From: Martin Gillam [Redacted]
Sent: 11 July 2020 20:59
To: Anita Gardner <Anita.Gardner@arun.gov.uk>
Subject: FW: CM/16/20/PL

The re-design of plot 8 (CM/16/20/PL) clearly ignores and conflicts with the officers report and my original concerns. My property adjoins the rear of the property which is designed with a much lower roof therefore I disagree with the applicant that the re-design of a 2 story house is *“equally accomodating of neighbours in terms of massing and scale”* and I strongly object to it.

Drg No: 190725/HT-F1-EL	Rev: A
-------------------------	--------

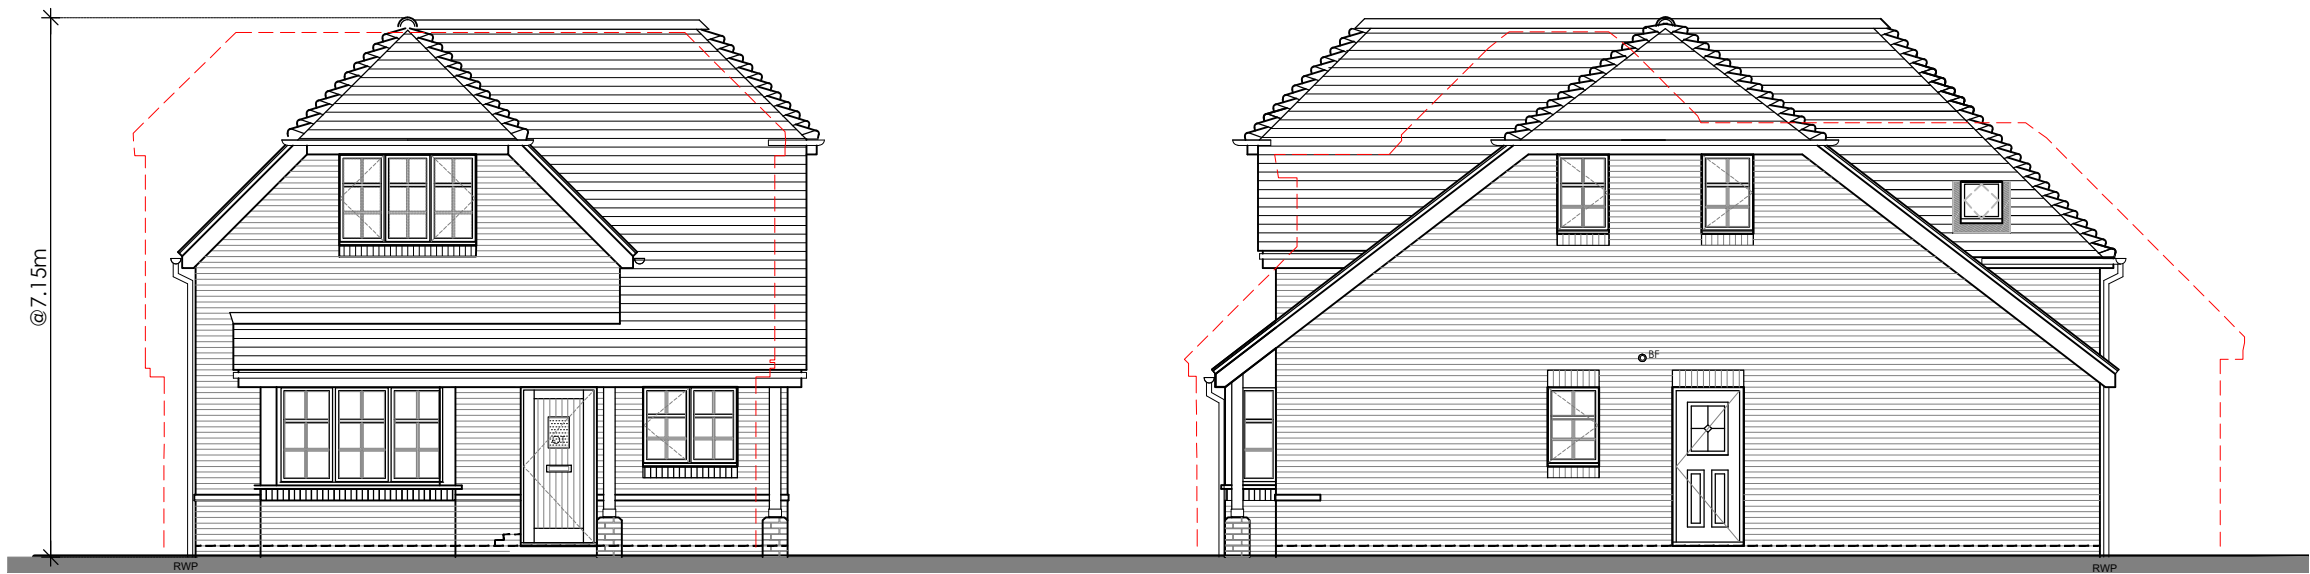
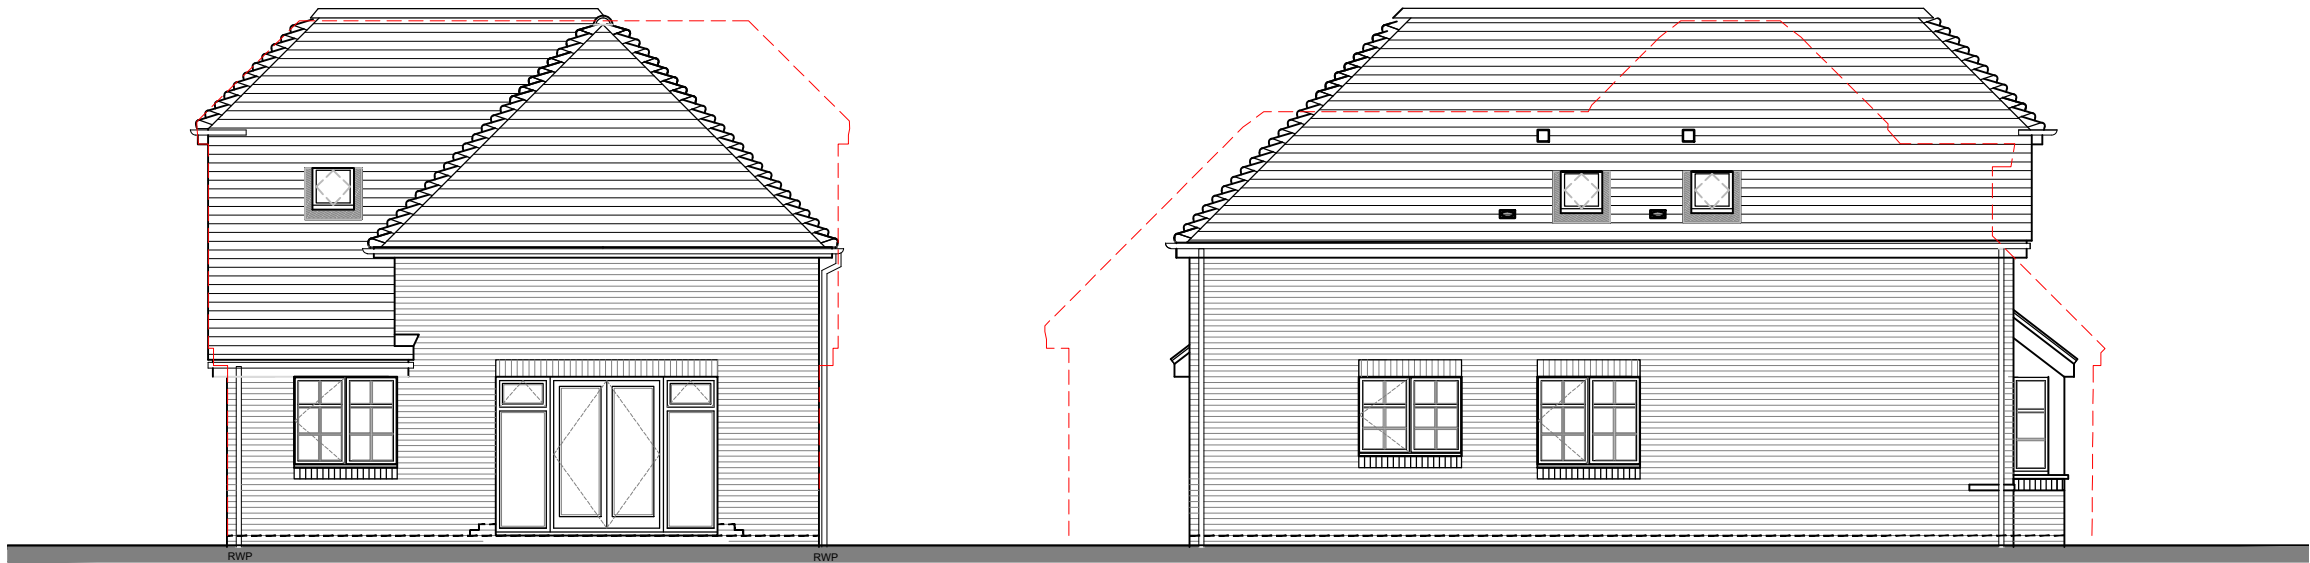
Regarding the approved plans (CM/64/19/PL) I am concerned by the lack of key measurements such as not stating the pitch and height of the roof or the distance to the boundary. The plans were also frequently changed and there are inconsistencies which make it very difficult to review. For example the roof of plot 8 started as a pitched roof with gable windows, then it shows a flat roof at the back, then a flat roof at the back front and the gable windows are gone. See below:

Drg No: 190725/HT-F1-EL Rev: A

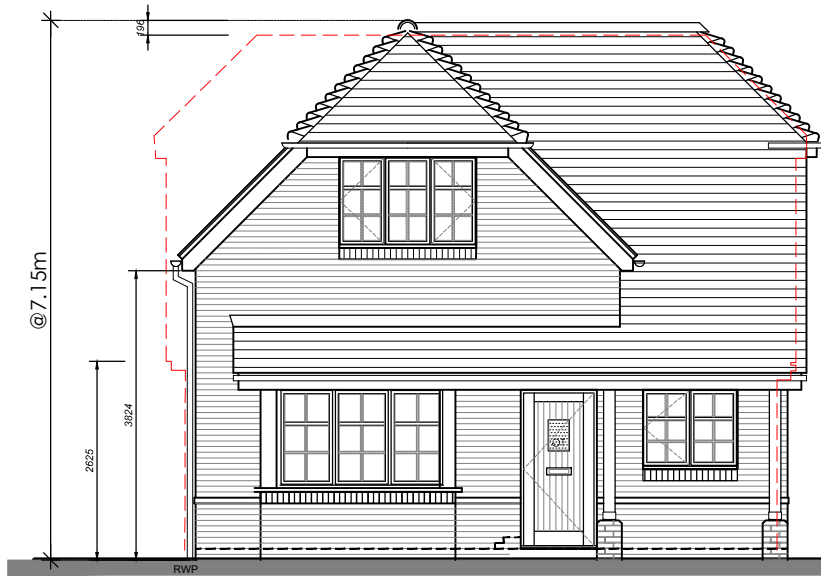
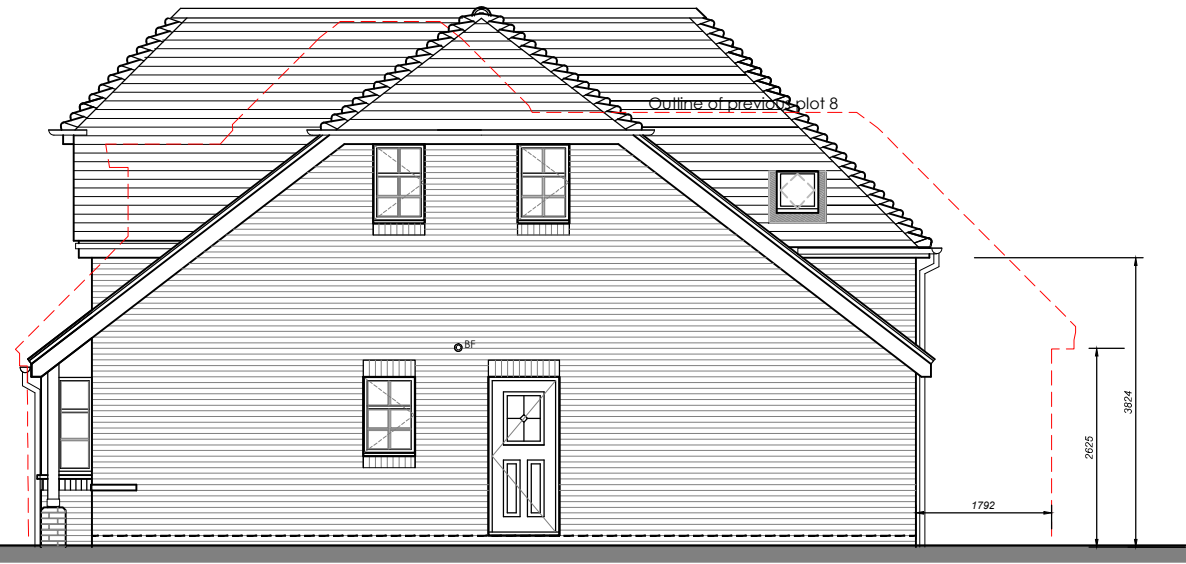
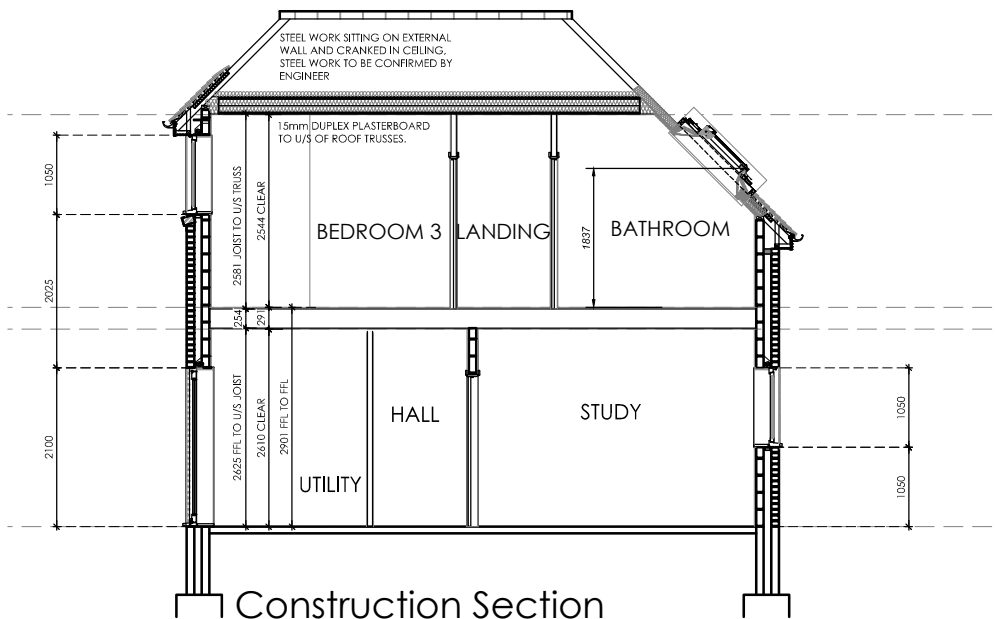
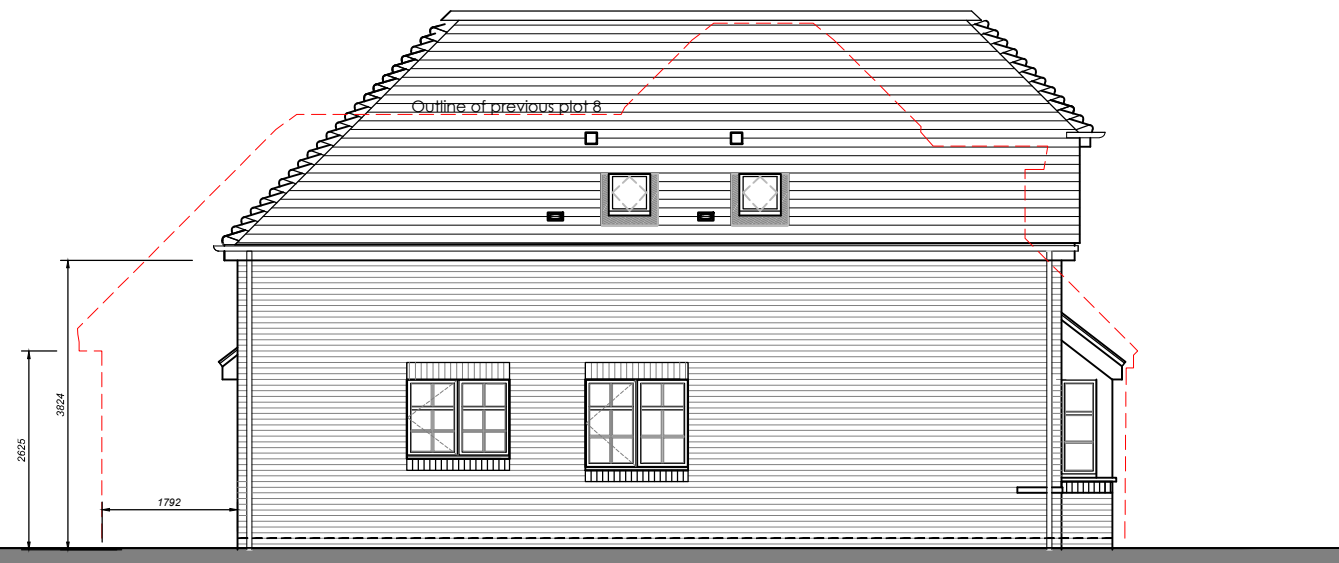
The architect has just added a "construction section", the ceiling height of the house is taller than standard. The plans state that the ground floor to the underside of the joist is 2625mm –see below. Normal ceiling height is just

over 2.3m. I and other neighbours have expressed concerns about massing, scale and light infringement therefore it is unacceptable that the architect wants to have abnormally high ceilings and the original application makes no mention of this.
